Please ask for: Mrs D Johnson
Email: daun.johnson@arun.gov.uk
Telephone: 01903 737762
Our Ref: WA/108/24/PL
Your Ref:
Date: 20th December 2024

Application for Planning Permission

Development: Erection of a re-purposed building for use as Class E (g) (iii) floor space, access, parking, drainage and landscaping. This application is a Departure from the Development Plan and is in CIL Zone 3 (Zero Rated) as other development.

Location: Stoneybrook Farm Eastergate Lane Walberton BN18 0BA

Ground Floor Plan

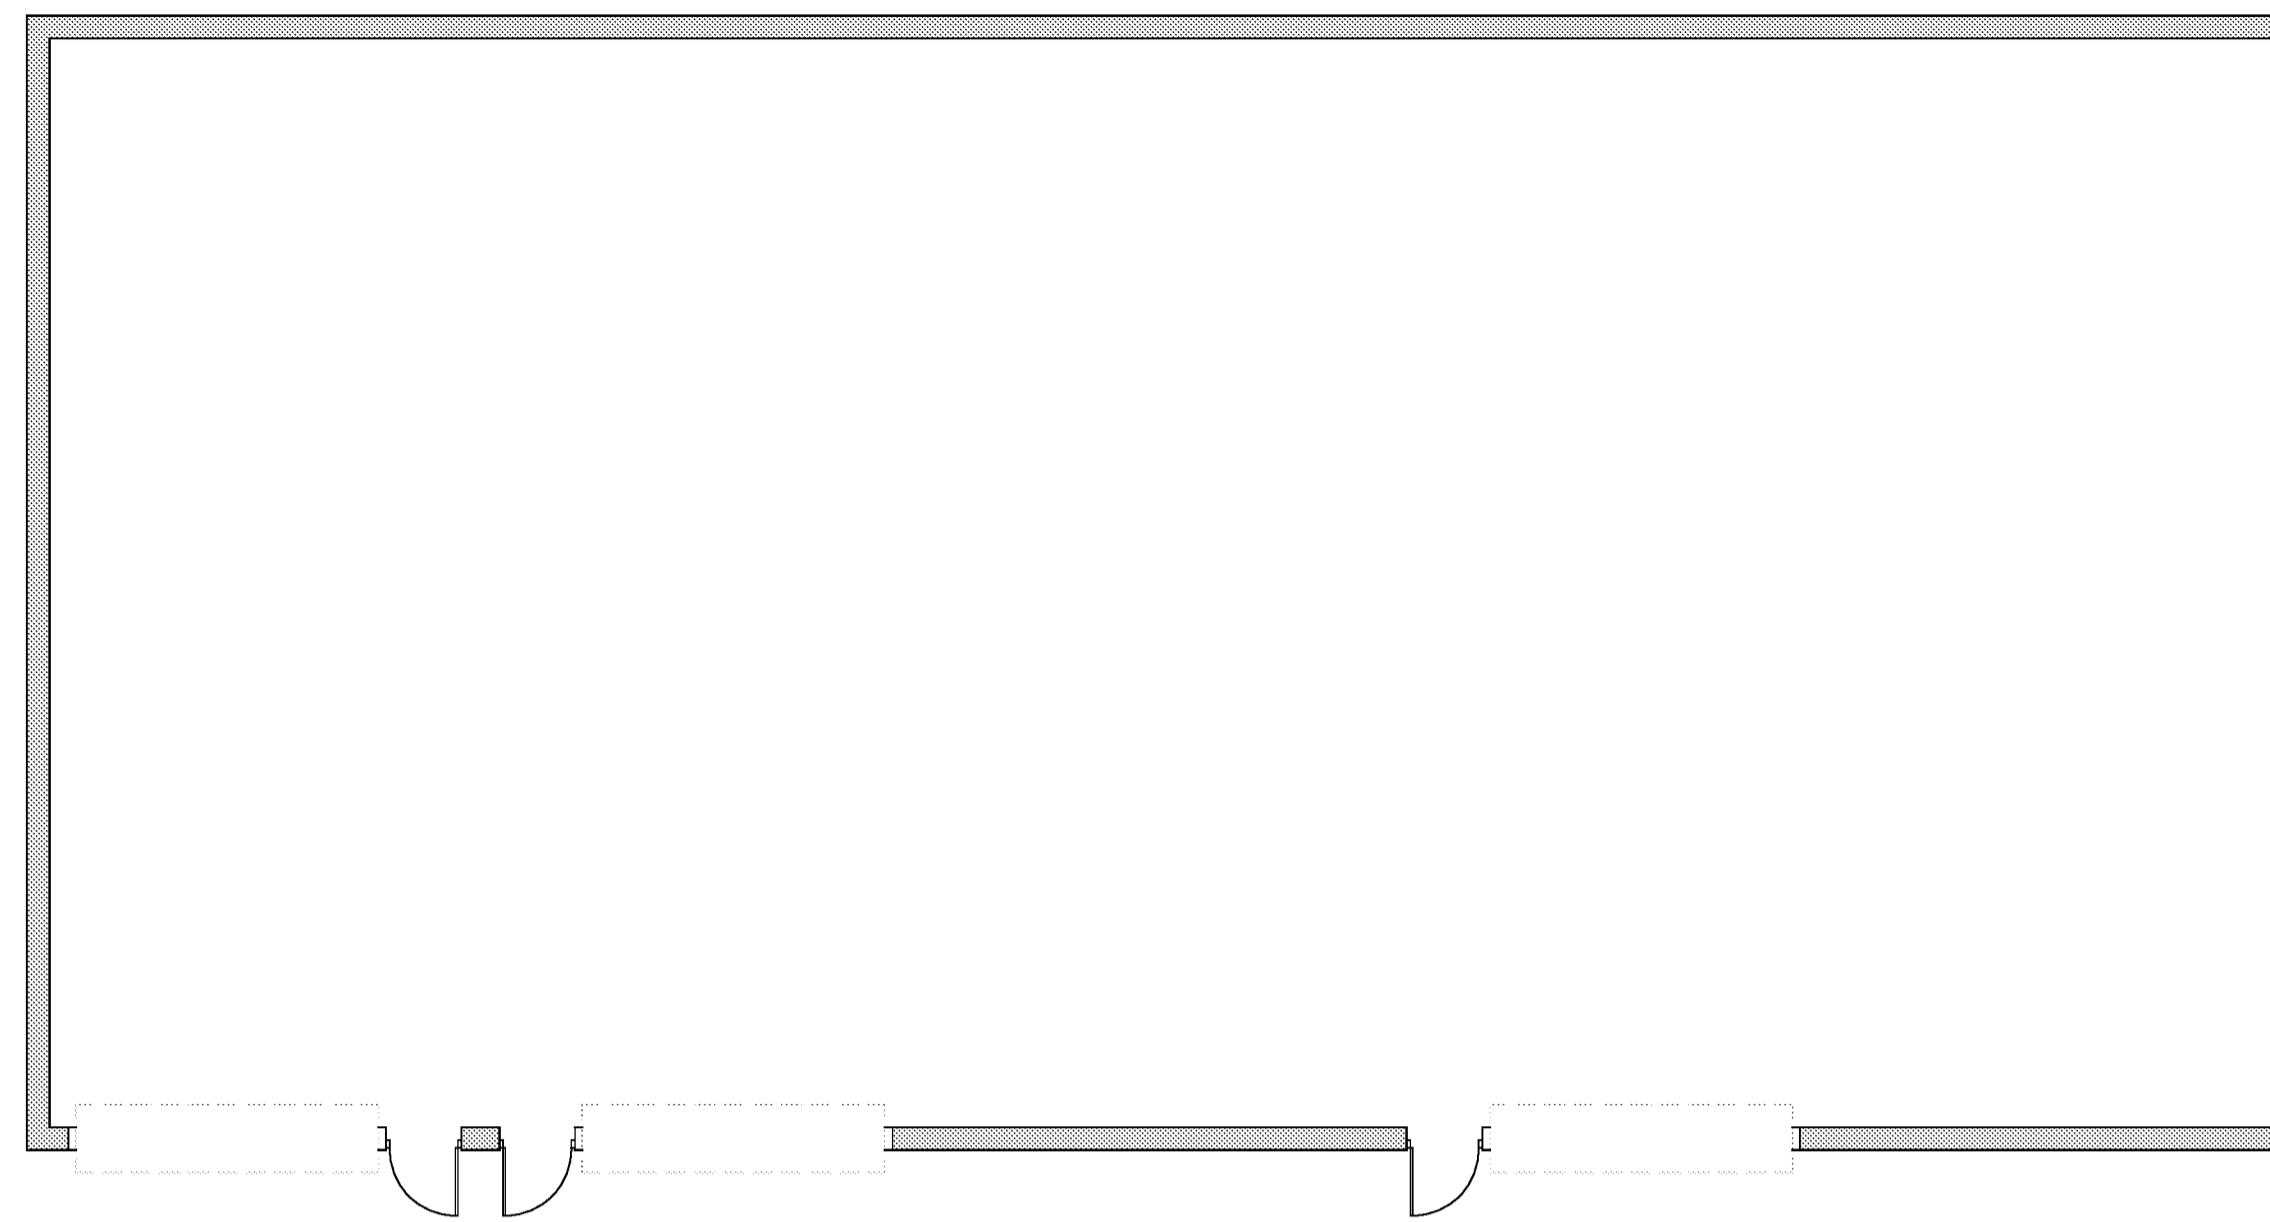
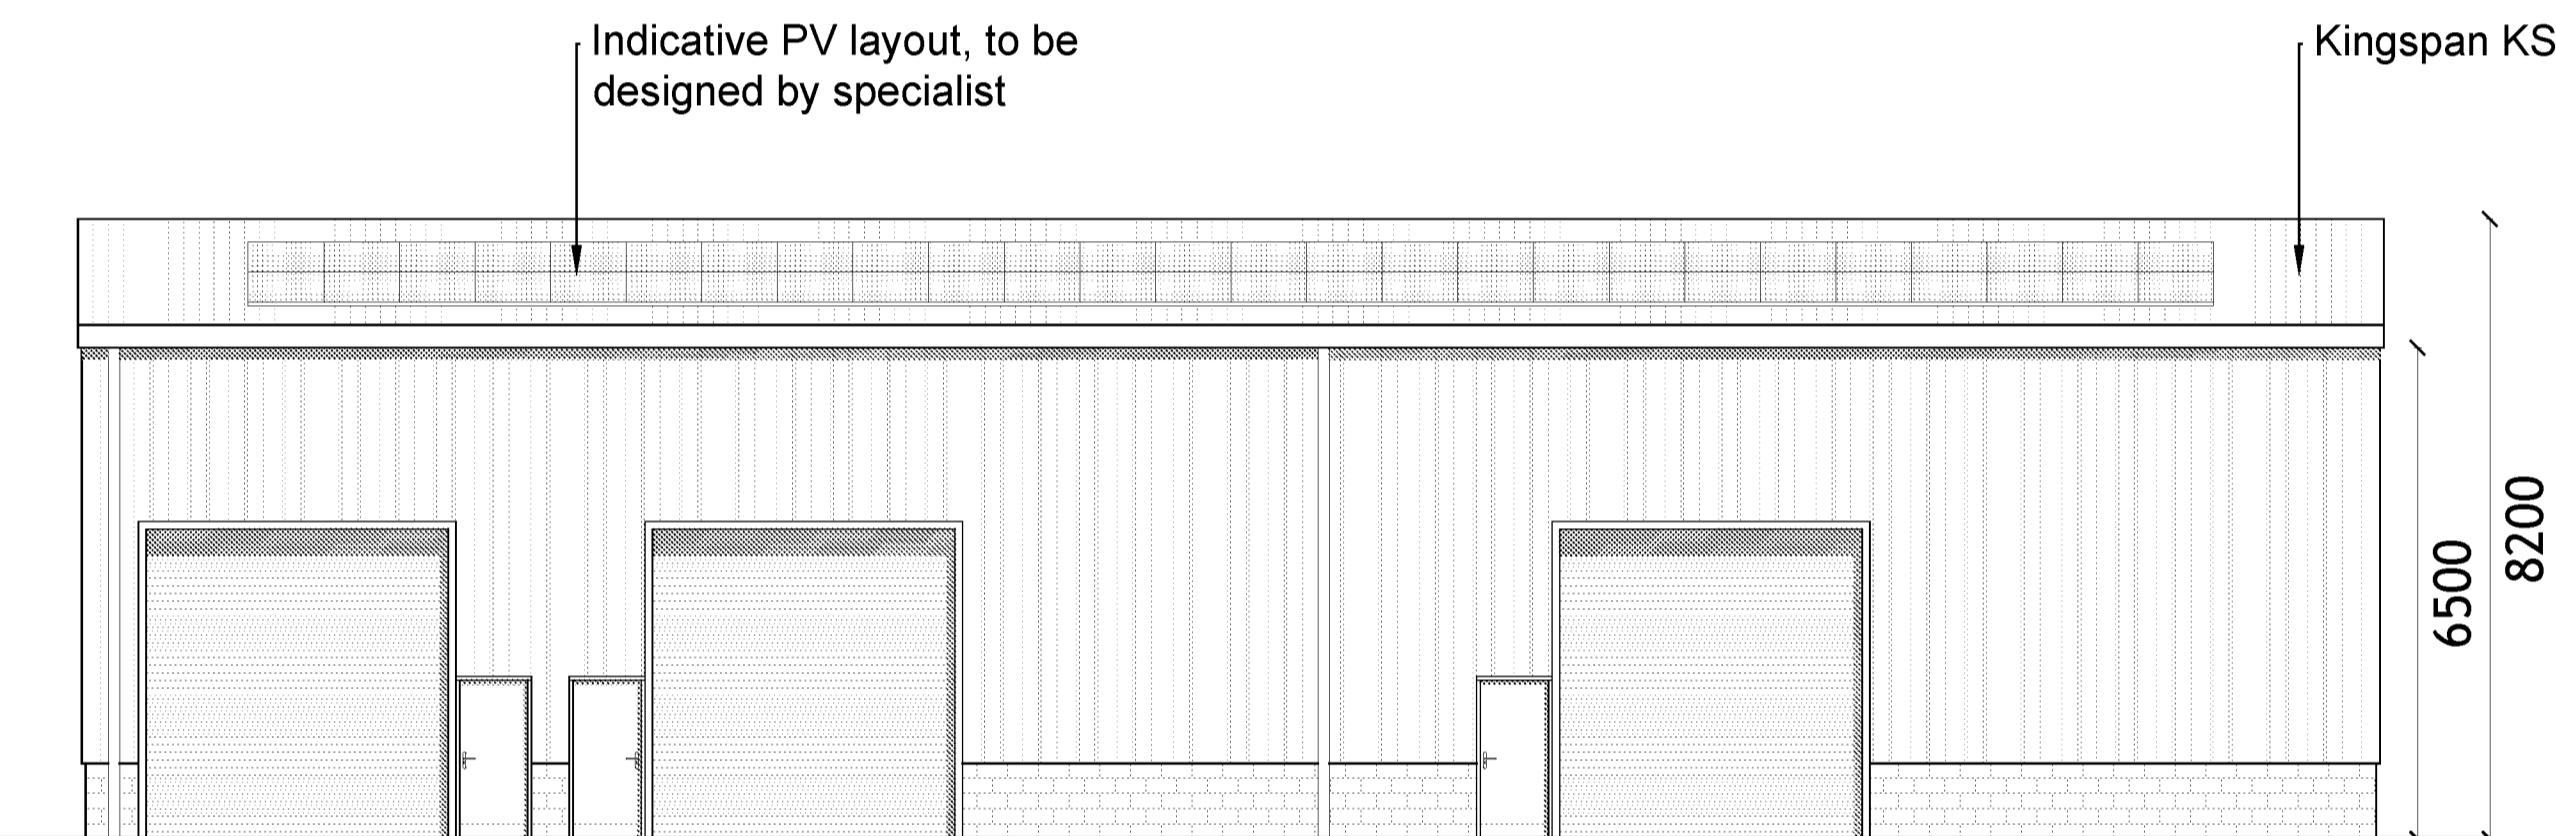
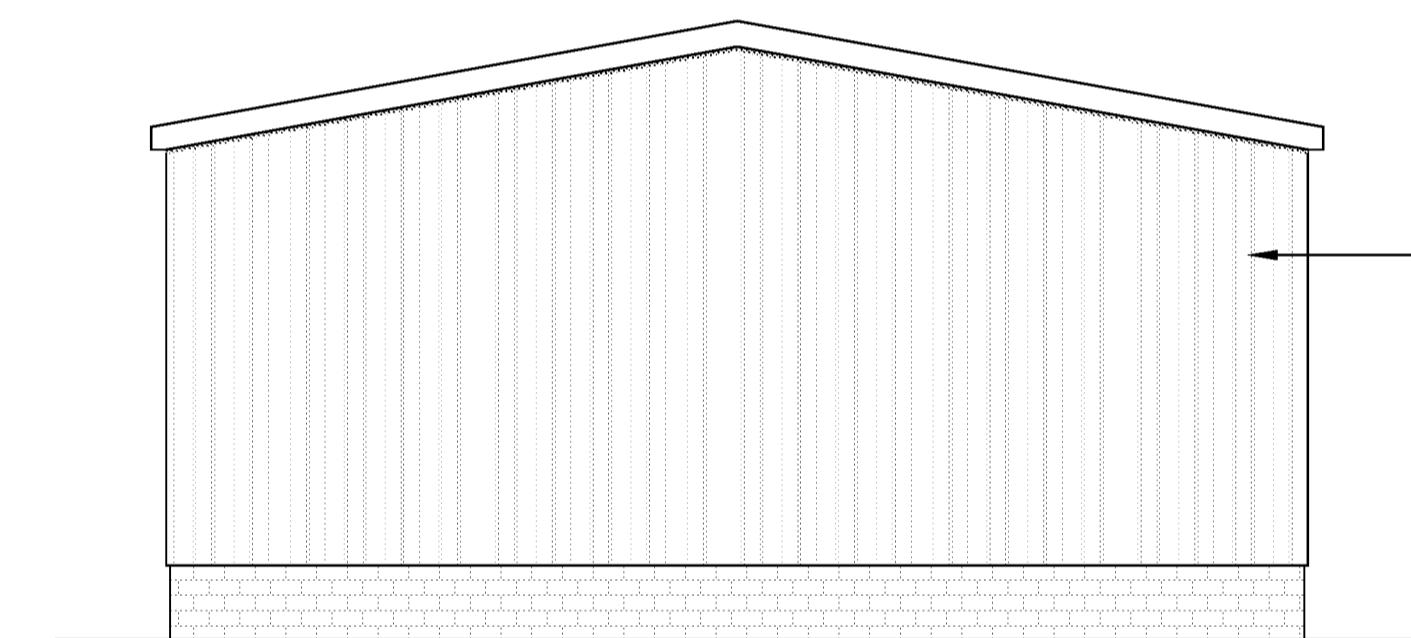
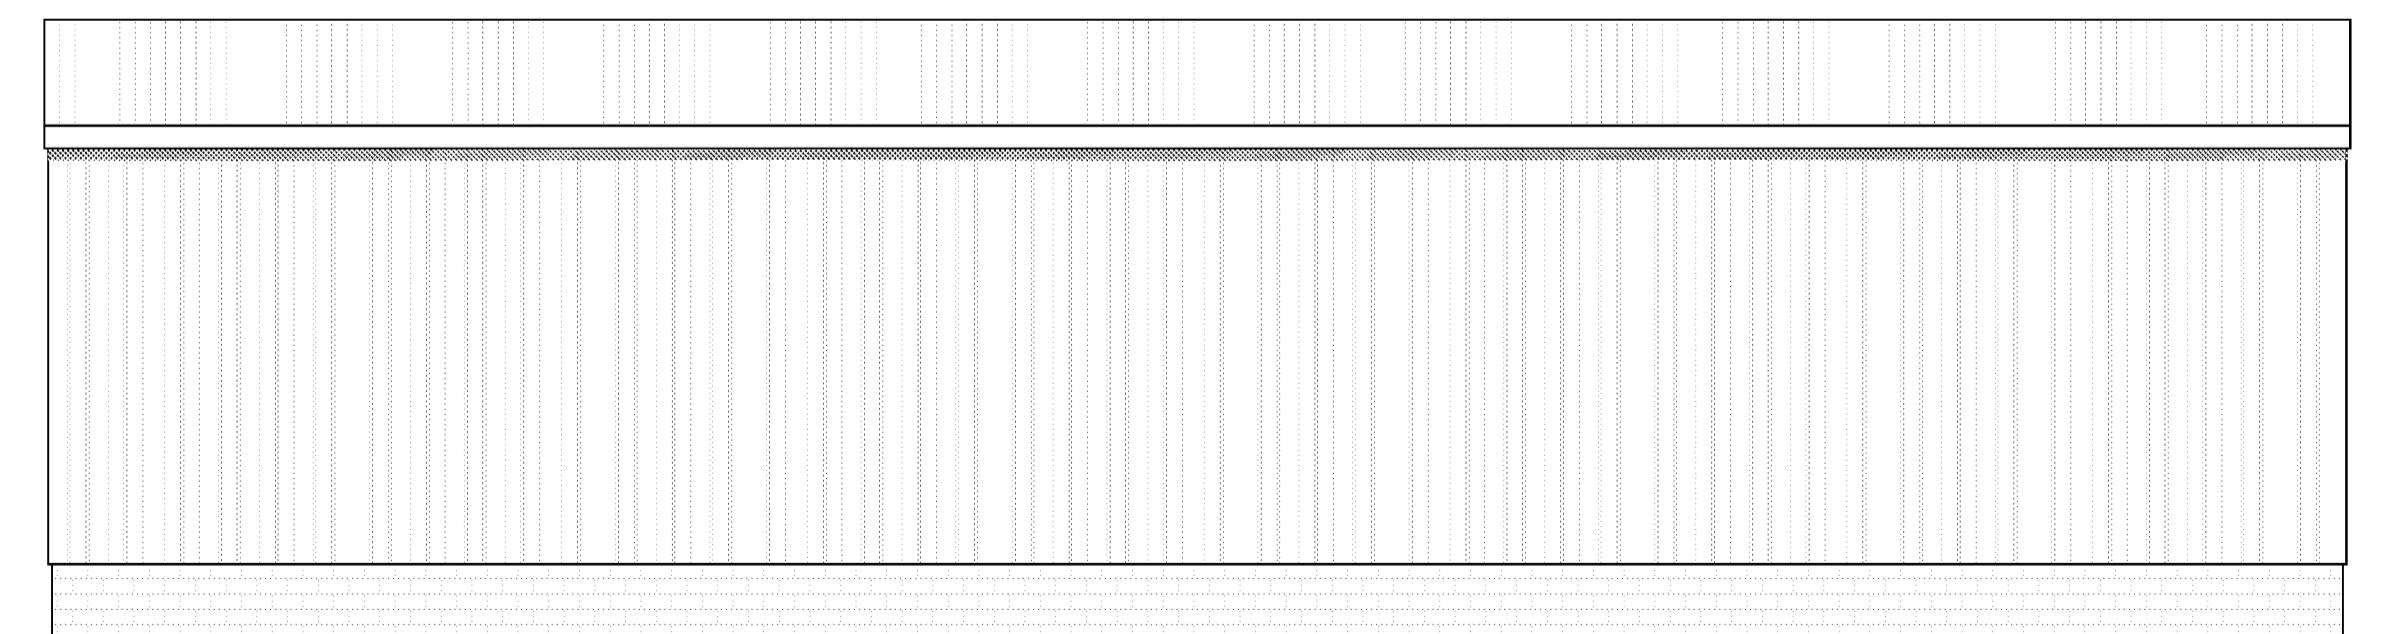
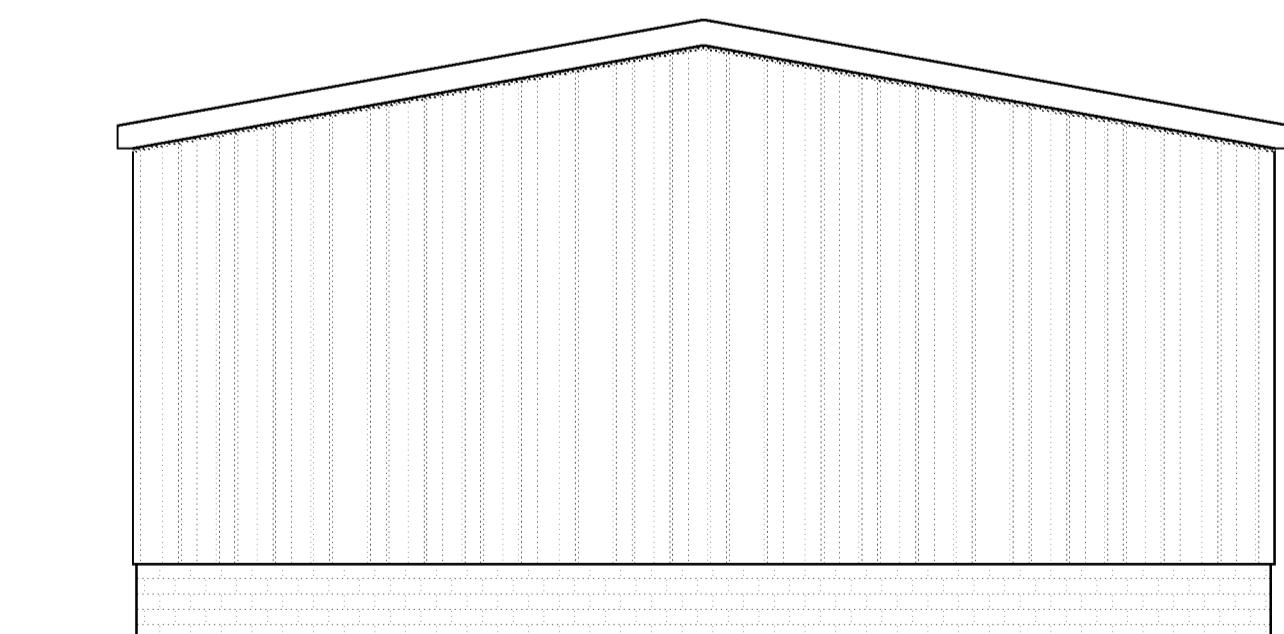
The floor plans for the building do not scale with the block plan. The legend on the floor plan and elevations is at a scale of 1:200 while the scale bar is at 1:100. Please clarify.
